**Howerton Services, PLLC**  
**License # P-1716**  
3513 Cathedral Bell Road  
Raleigh, NC 27614  
(919) 270-3460

Subject: 387 Ballard Road  
Fuquay Varina, NC 27526  
Plan Revision Letter  
Harnett County Permit #: SFD2302-0043

S1 FOUNDATION
 1/4"=1'-0"

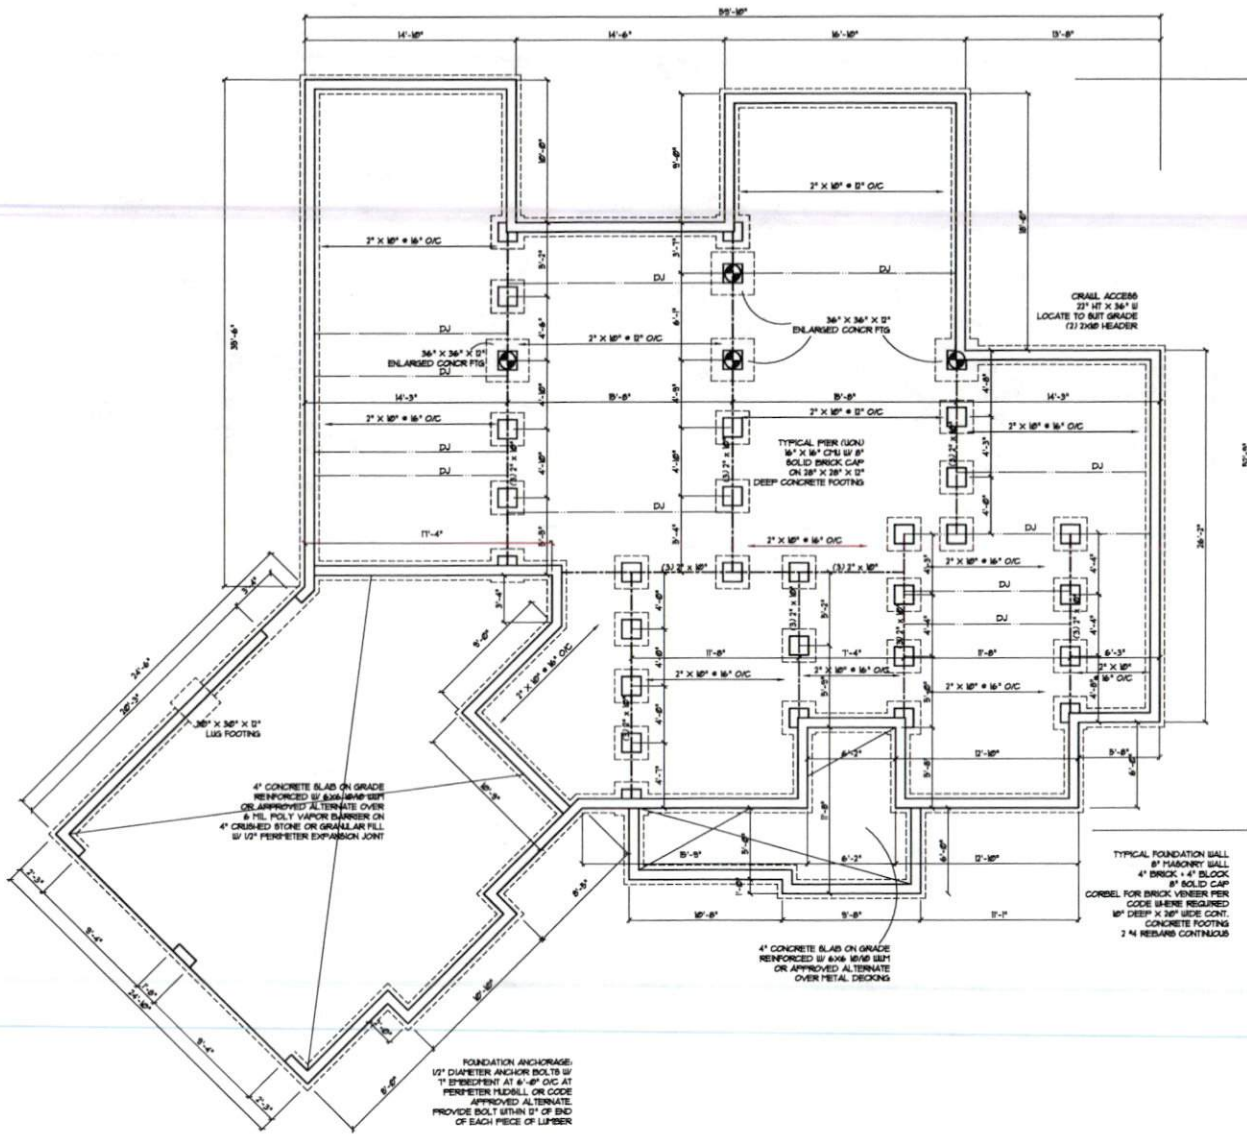
- The 2 - #4 bars shown on the plans for the footings will not be installed. Removing the rebar from the footings is acceptable.

The footings without the rebar meet all the requirements of the 2018 North Carolina Building Code for Residences.
